## CITY OF PORTLAND

August 20, 2003

RE: 27 Clifton Street – 126-E-005 – R-3 zone – permit application #03-0898

I am in receipt of your permit application to construct a new wrap-around deck with new stairs at 27 Clifton Street. Your permit application is denied because your proposal does not meet the required rear setback and exceeds the maximum lot coverage for the R-3 residential zone.

27 Clifton Street  
Portland, Maine

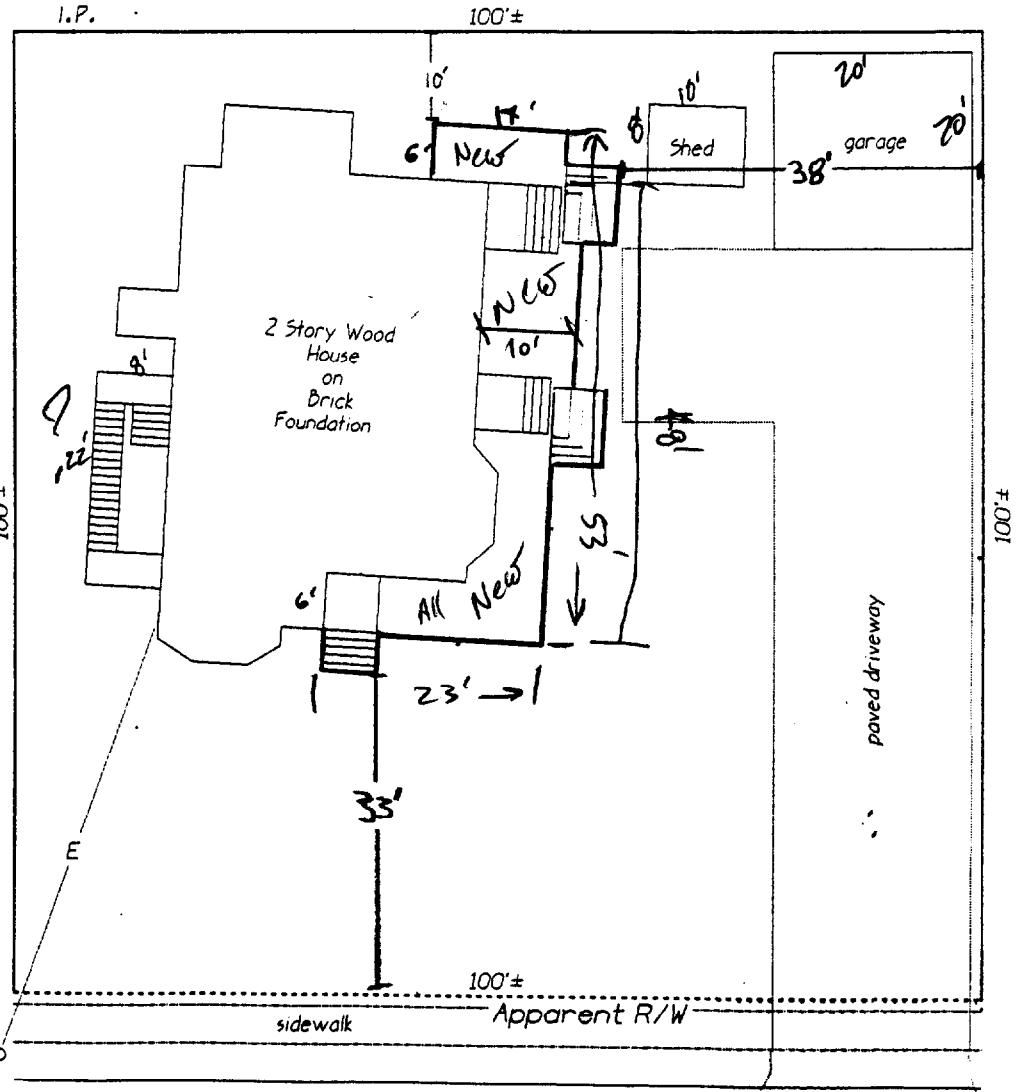
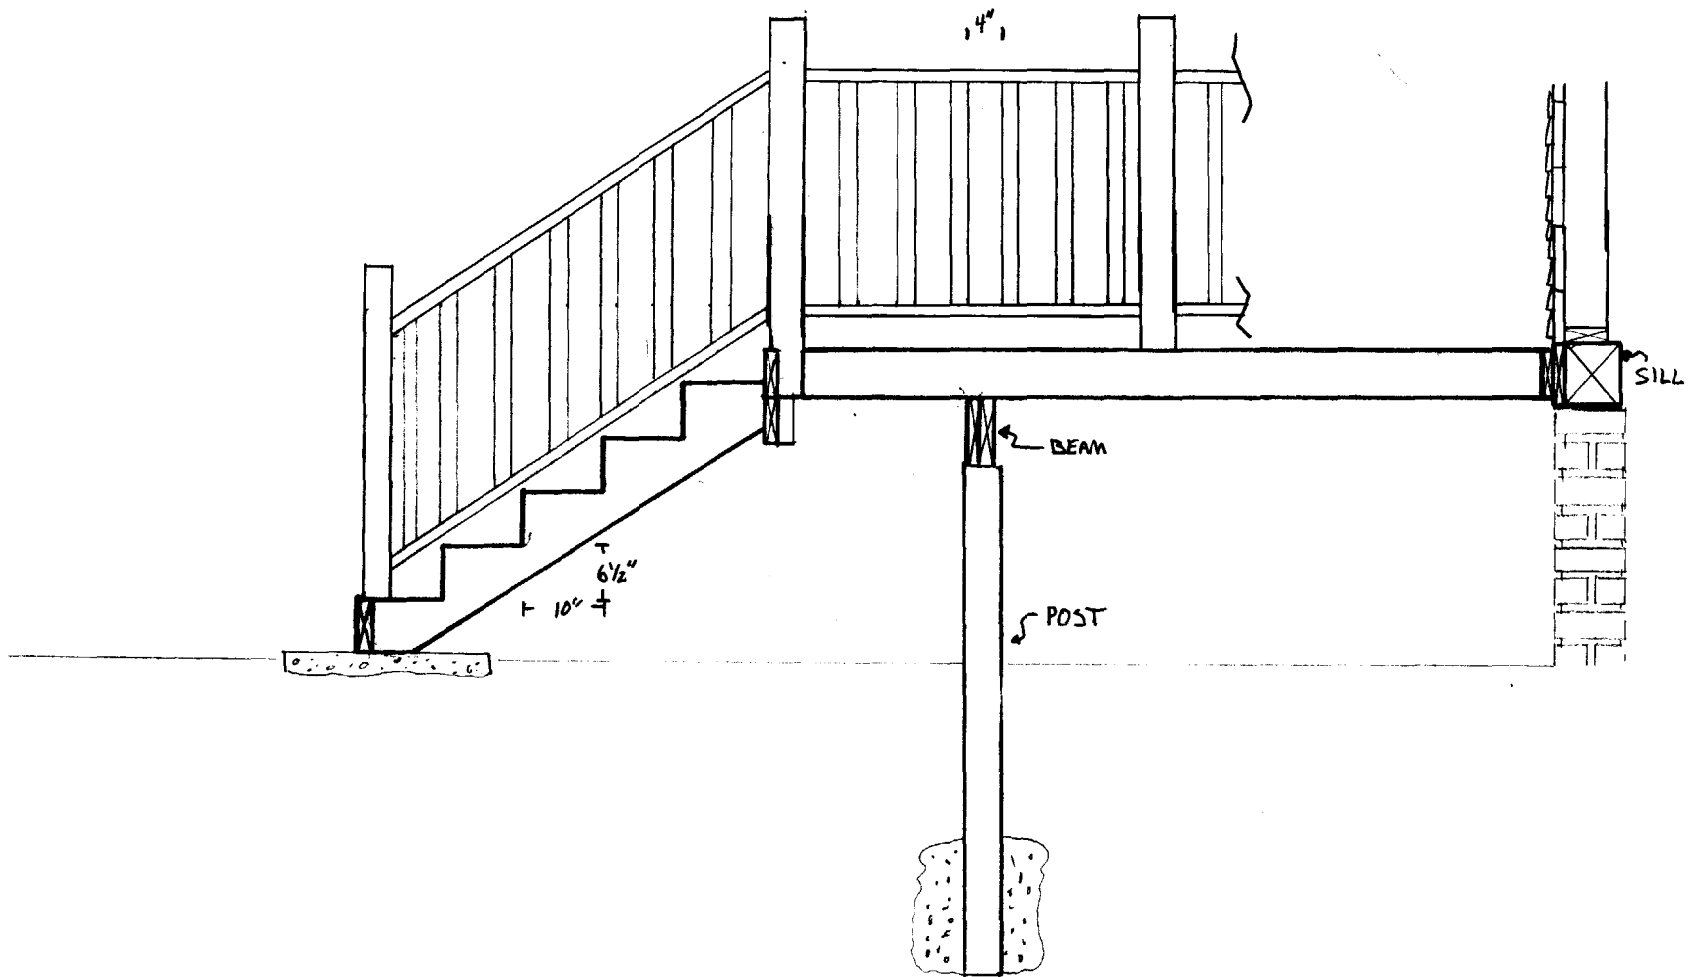
Section 14-90 requires a rear yard setback of twenty-five (25) feet instead of the ten (10) foot rear setback that you are showing. Section 14-90 also restricts the maximum lot coverage for a lot in an R-3 zone to twenty-five (25) percent. Your lot is 10,000 square feet in area. Twenty-five percent of your particular lot would set the maximum lot coverage to 2,500 square feet. A total square footage of your building area adds up to approximately 2,958 square feet. Your proposal is over the maximum allowed lot coverage.

Apparently you have already begun construction on this project without the benefit of first obtaining a building permit. A Code Enforcement Officer required you to come in for a building permit. Your construction shall be removed in order to come into compliance with the ordinance within ten (10) days of this letter.
